Your ref:
Our ref: 21/01060/F
Please ask for: Mrs Lesley Raby
Direct dial: 01553 616818
Direct fax: 01553 616652
E-mail: borough.planning@west-norfolk.gov.uk

Details: **Demolition of existing dwelling and replacement for four new detached dwellings. at 25 Foresters Avenue Hilgay Downham Market Norfolk PE38 0JU**

I have received a planning application as detailed above but cannot process it until I receive some more information:

PROPOSED GROUND FLOOR PLAN

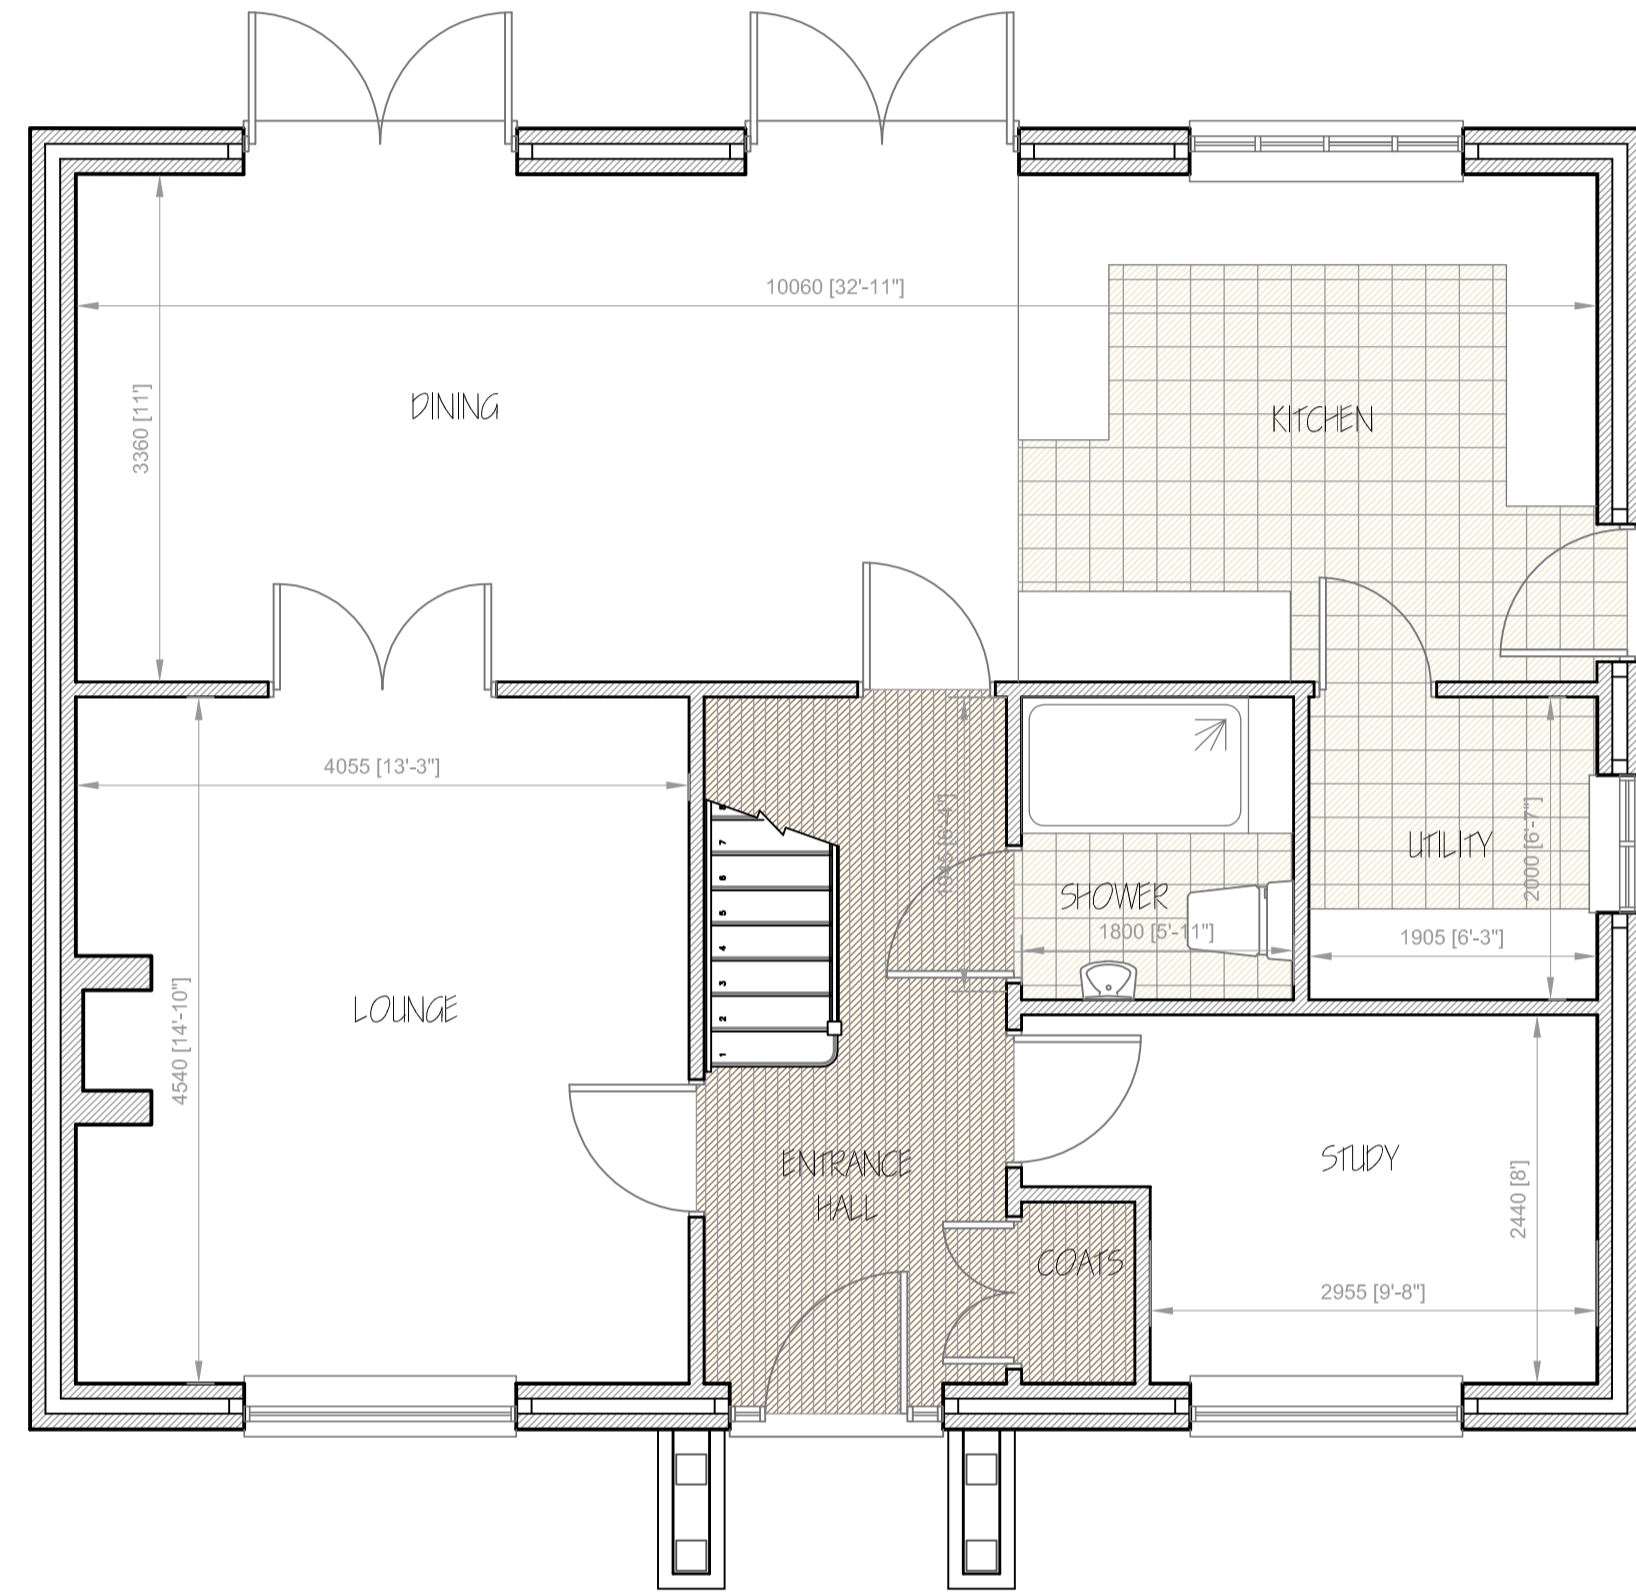
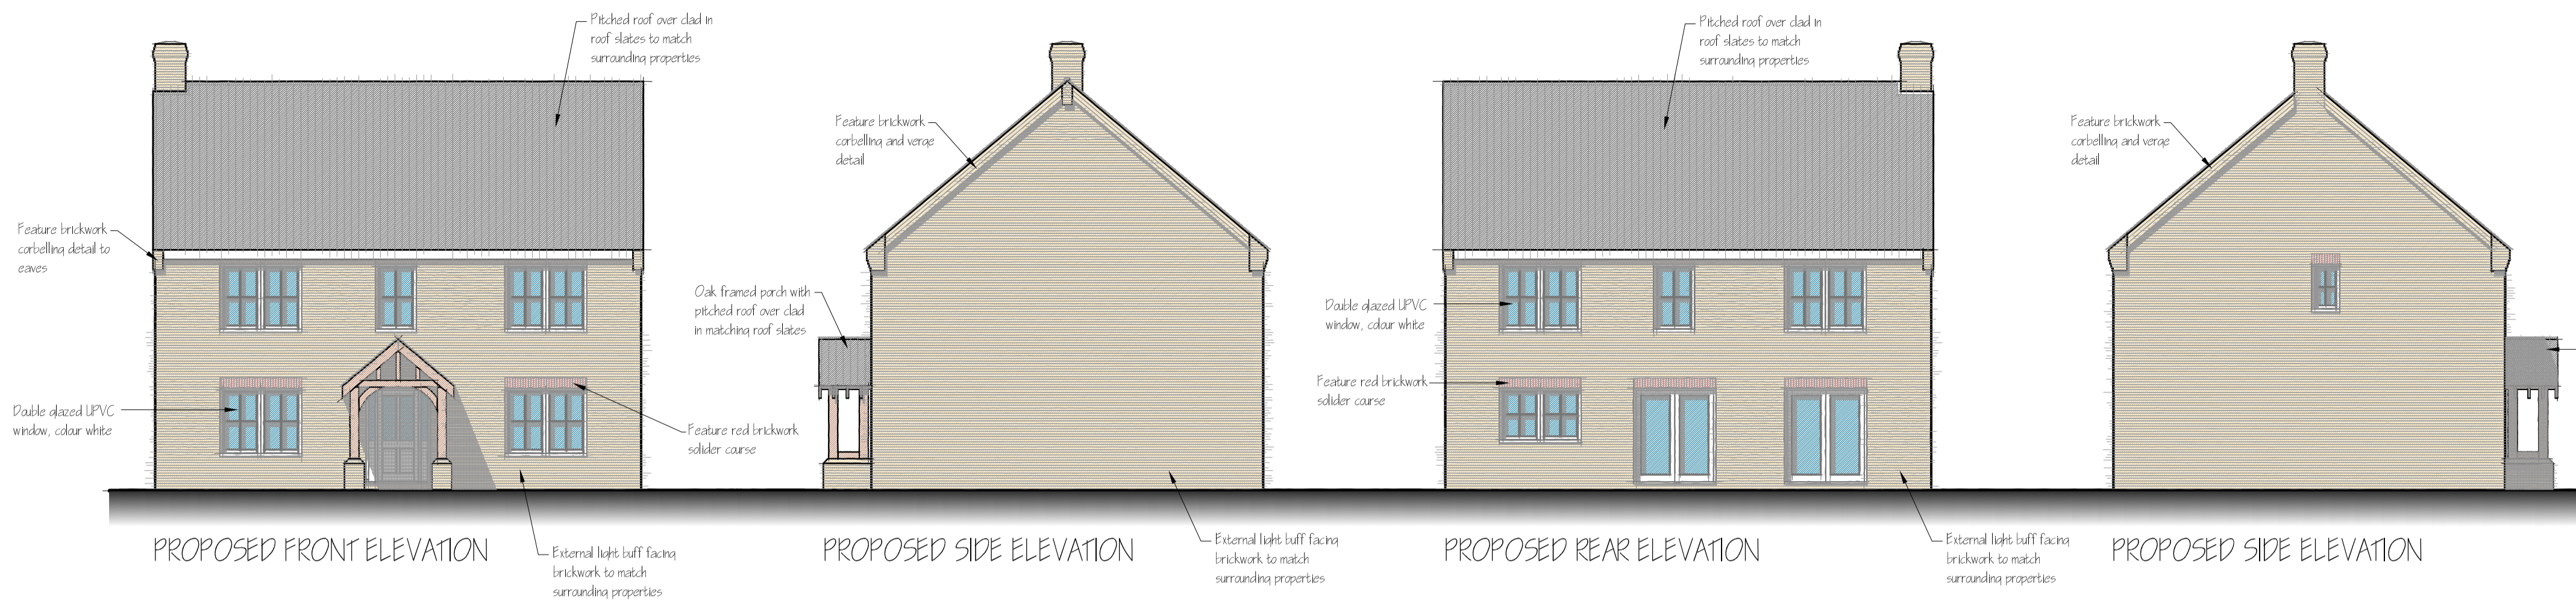
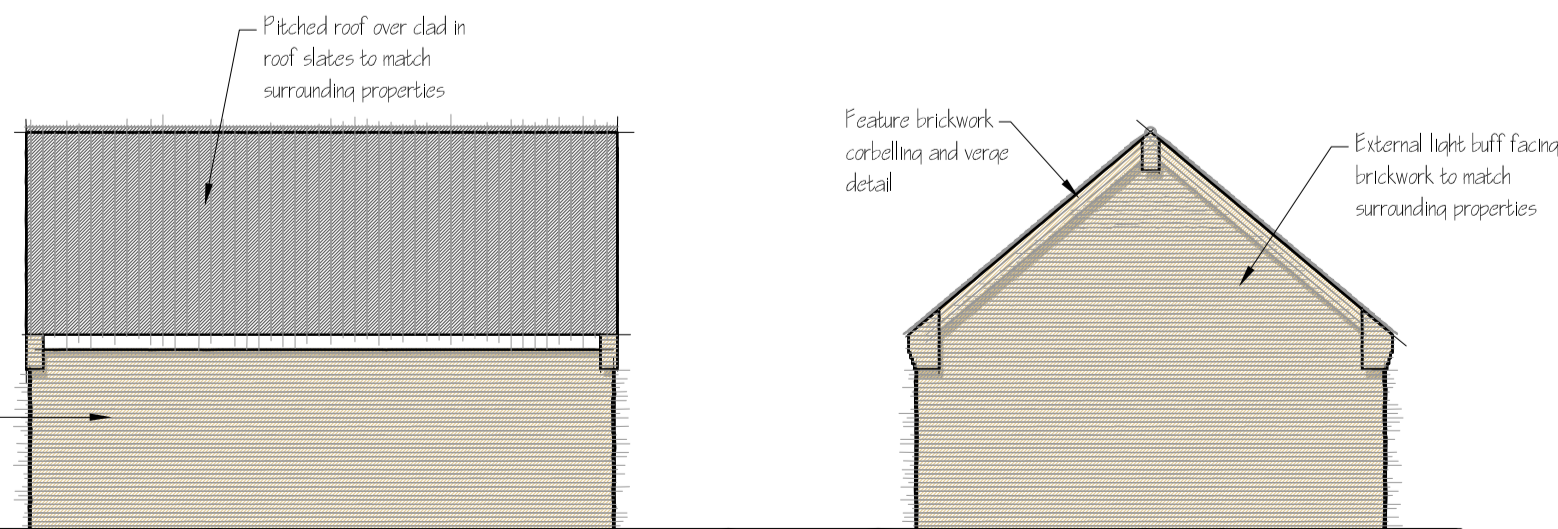
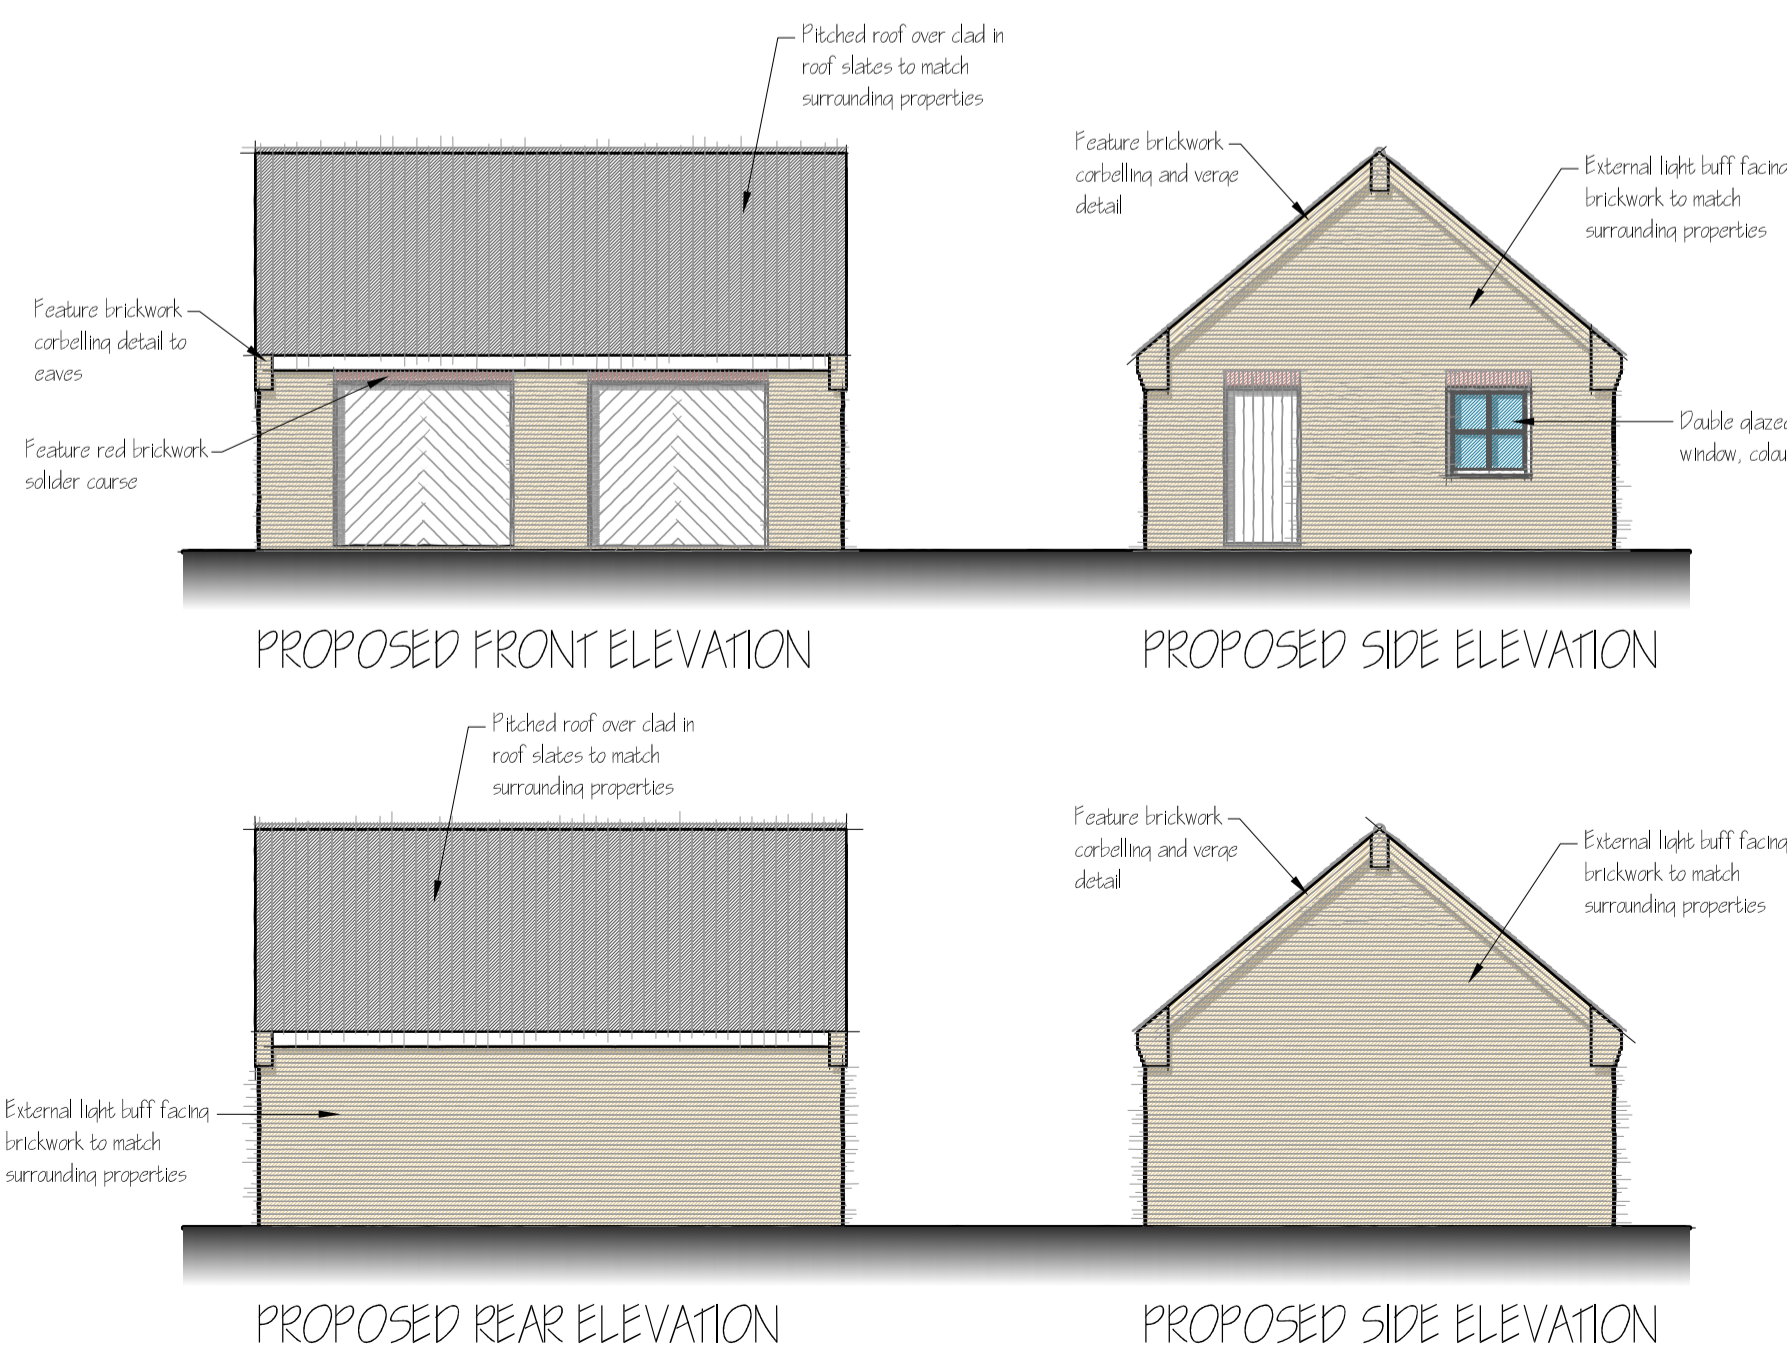
4. Provide roof plans for the new dwellings and garages
5. The plan for plots 2 and 3 show a kitchen door and utility window on the floor plan which is not shown on the elevation. Please amend.
